Project Name: *Springer*

DRB Comments

RE: Tract 7, Lands of Springer Transfer Company

RE: Tract 7, Lands of Springer Transfer Company

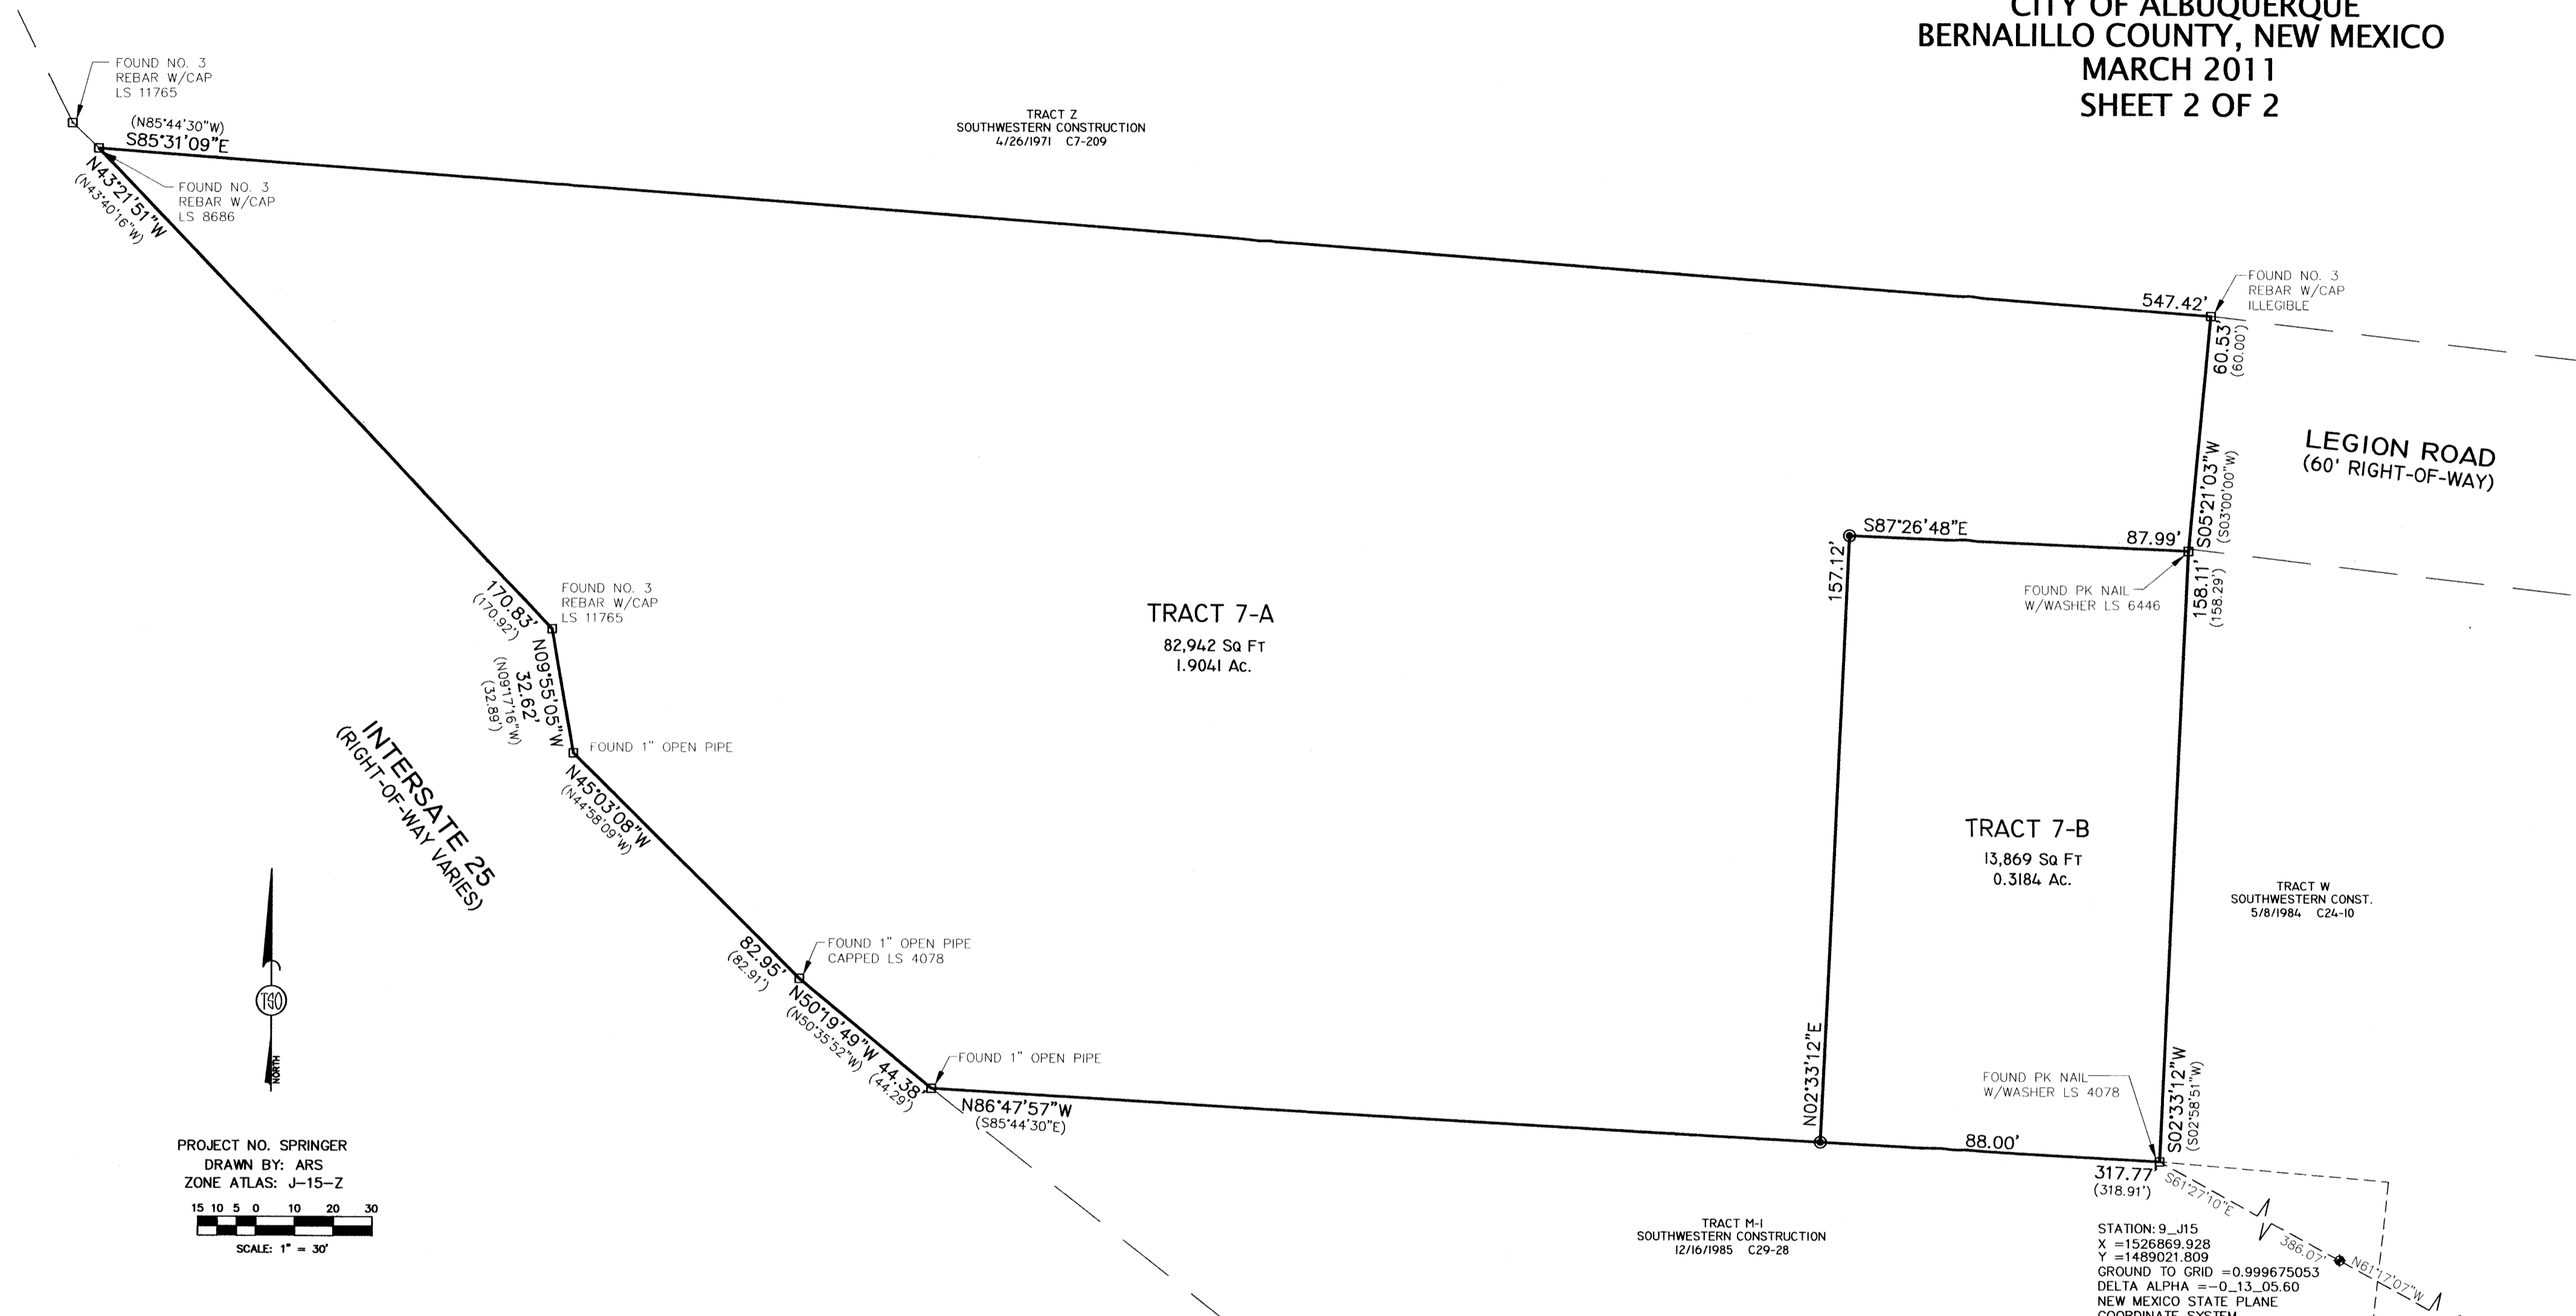
The Zoning Code requires that each building meet its parking requirements on each lot – parking calculations are needed to demonstrate that there are enough parking spaces within the proposed lots, or a parking variance would be required.

For example, it appears the building on proposed Tract 7-B is 3,000 sq ft which would require 15 parking spaces, but only 12 are shown.

Per the applicant's letter dated April 20, 2011, parking requirements on each lot have been met.
